From: [REDACTED]
Sent: 28 June 2023 16:57
To: Planning
Subject: 3/2023/0452 Northcote

Following the meeting of the parish council, we would like to say that we don't object in principle to them expanding their business. Northcote generates lots of revenue and jobs in the area.

Drawing title
GENERAL ARRANGEMENT PLAN

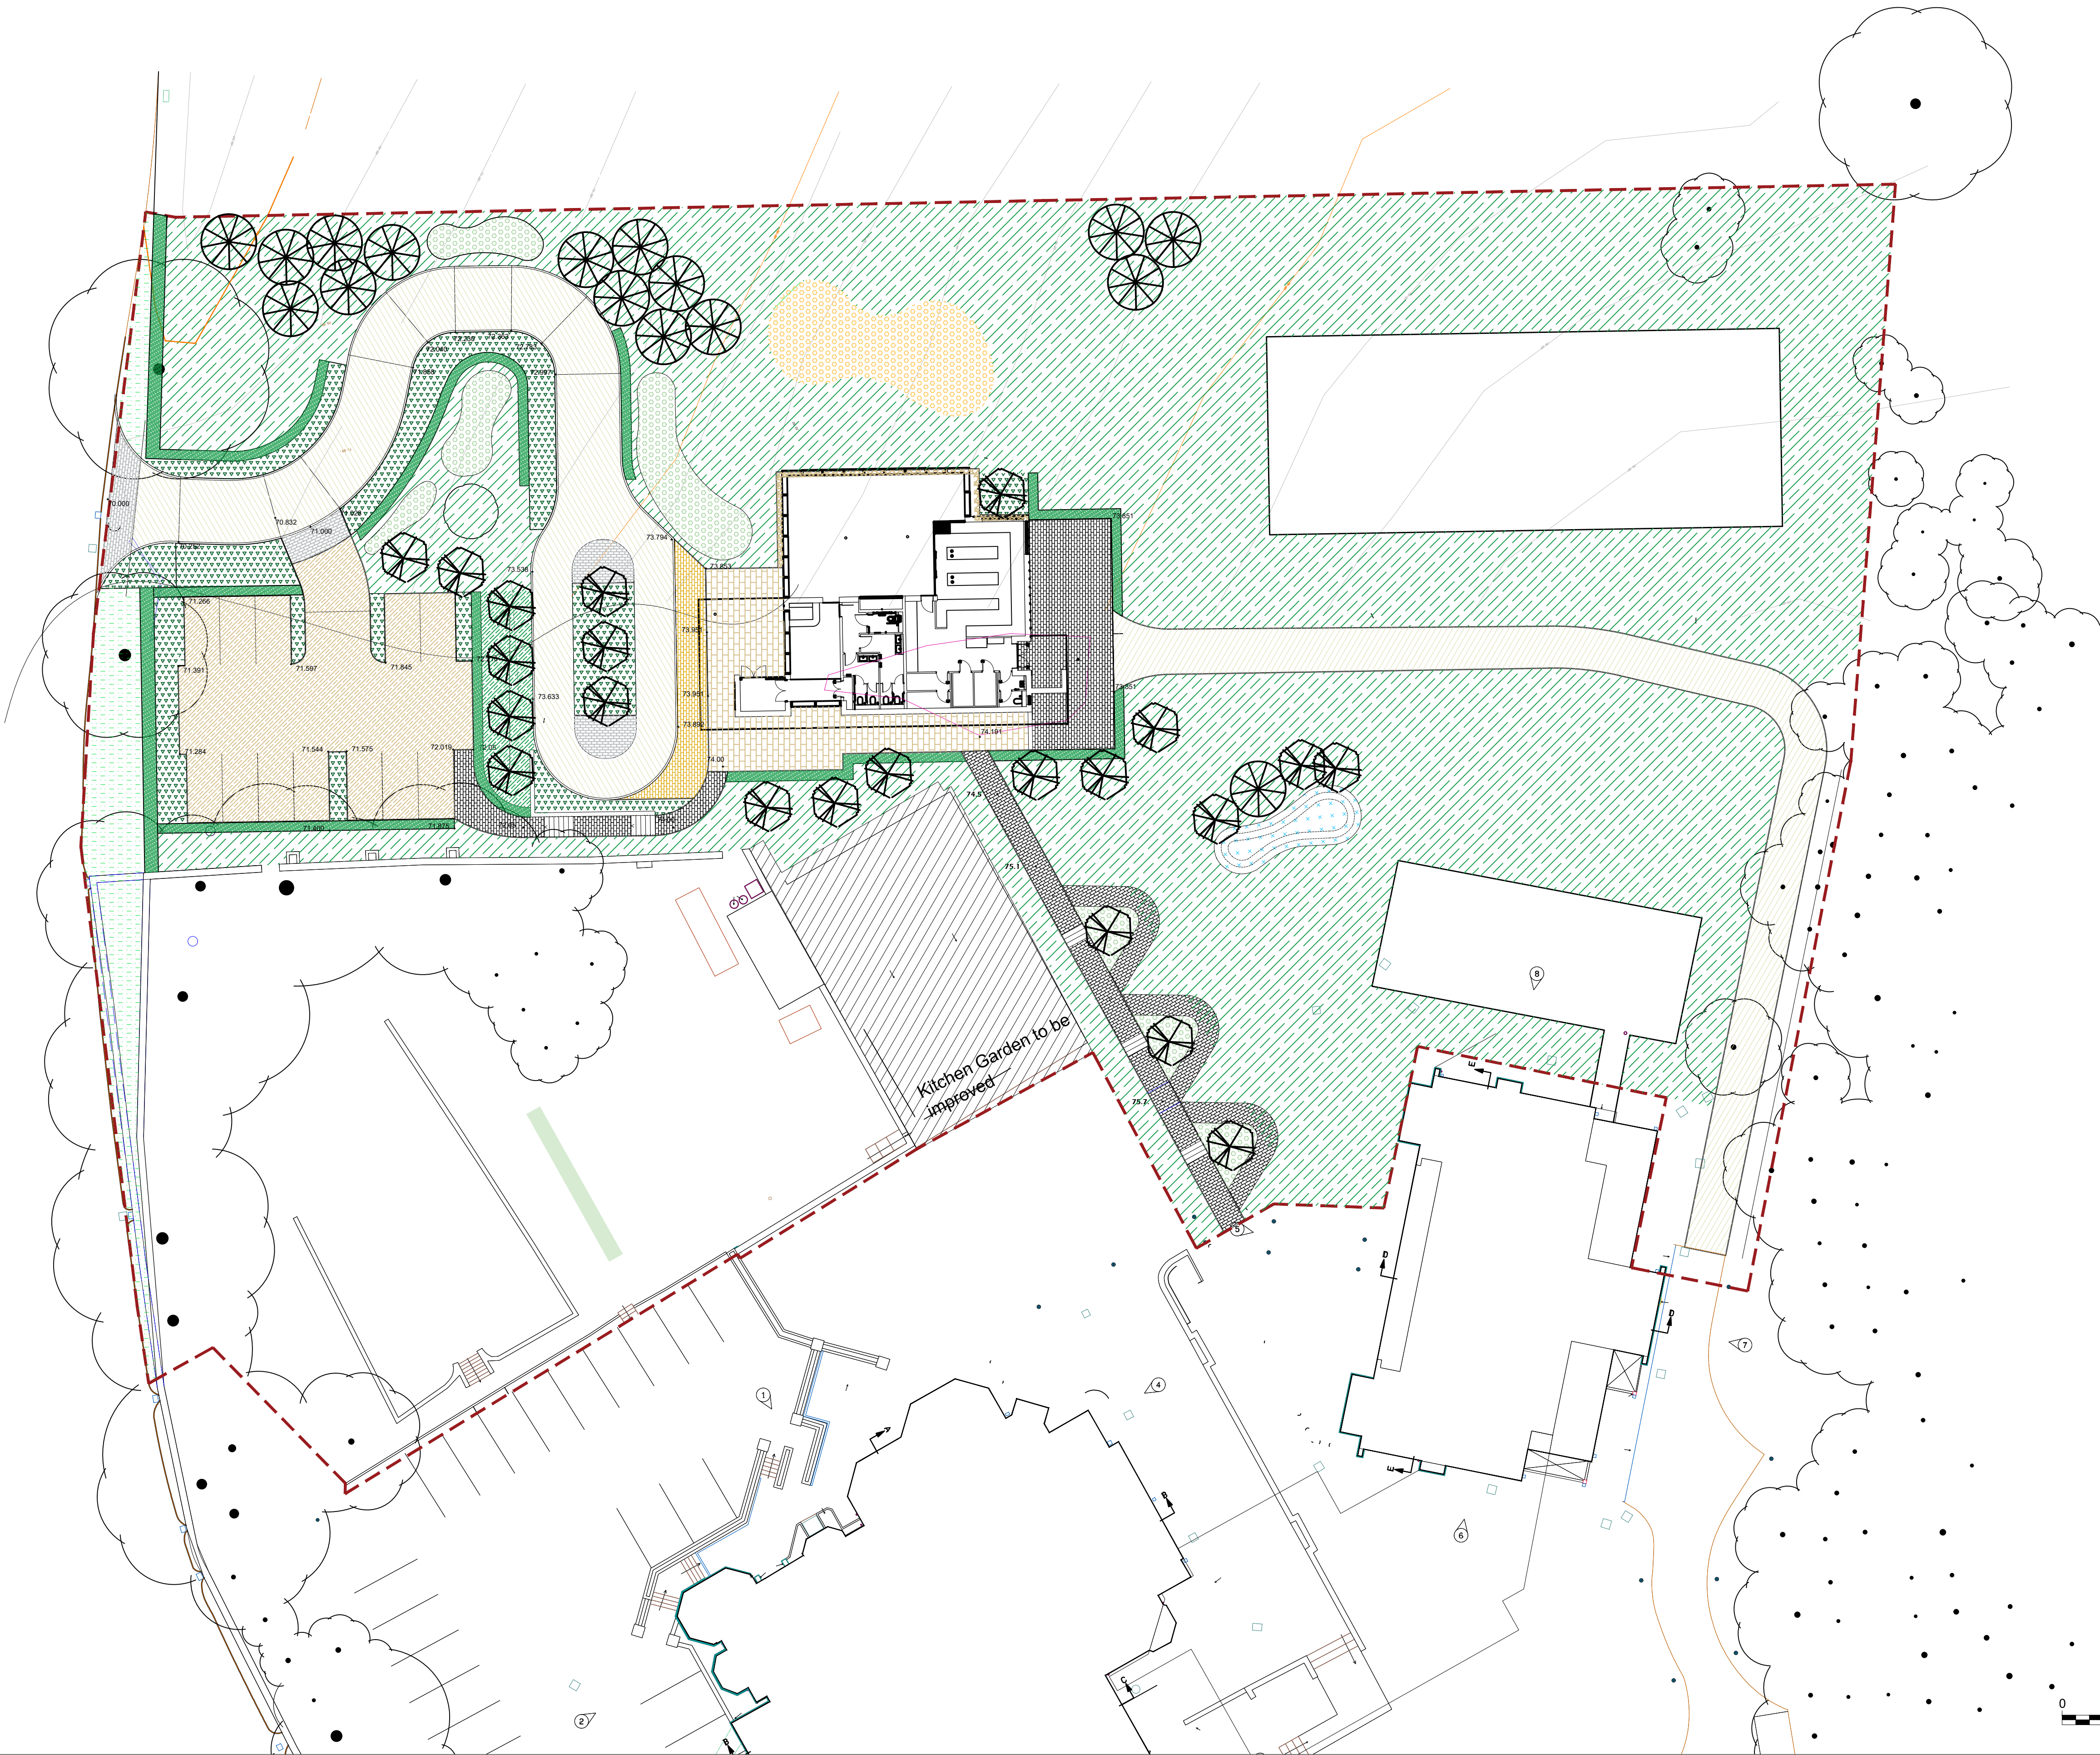
The concern is just the positioning of the new road accessing the parking for it. It's just a few yards from Northcote stud and the one opposite. I note that the average speed is low however this is due to the narrowing of the road the bends and the fact that lots of horse boxes and commercial vehicles use it. Langho football club also impacts with road parking and lots of children getting in and out of cars on occasions.

In the notes there are only 9 spaces for cars in the carpark - we do not feel this is enough.

Could the exit of vehicle from the premises be re looked at ?
